Application for a non-material amendment following a grant of planning permission.

Conversion of attached garage to habitable space, single storey rear extension, new french doors to rear elevation & replacement of existing flat roof with new pitched roof at rear.

Reference number: FG/28/19/HH

6. Non-Material Amendment(s) Sought

West Elevation

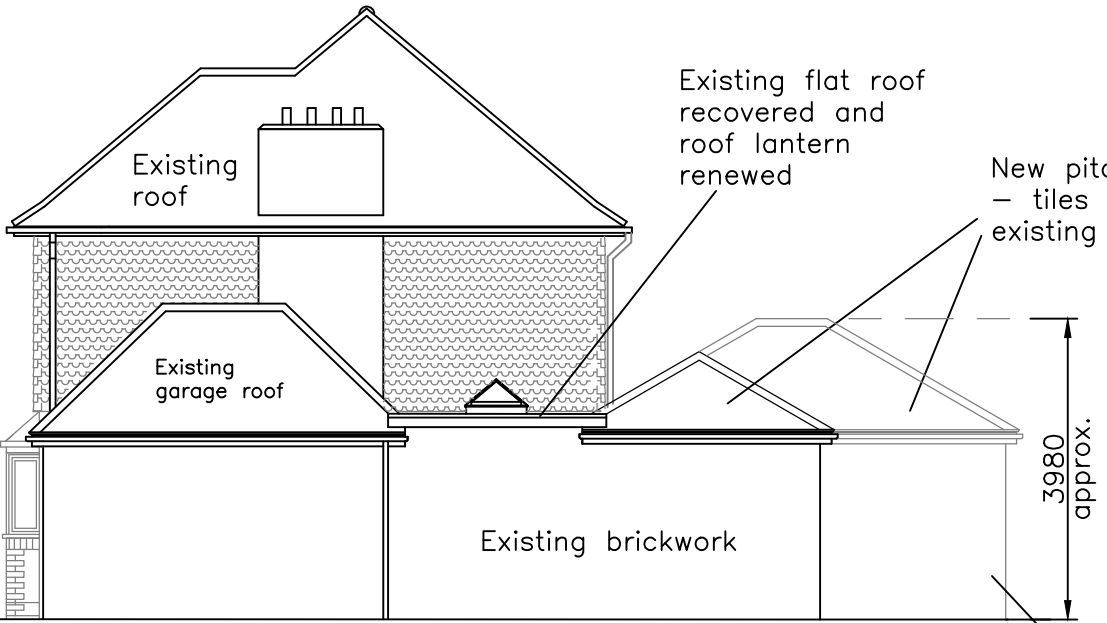
Omission of proposed patio doors to extension on rear North elevation and replacement with French doors and sidelights. Minor repositioning of window to extension West elevation.
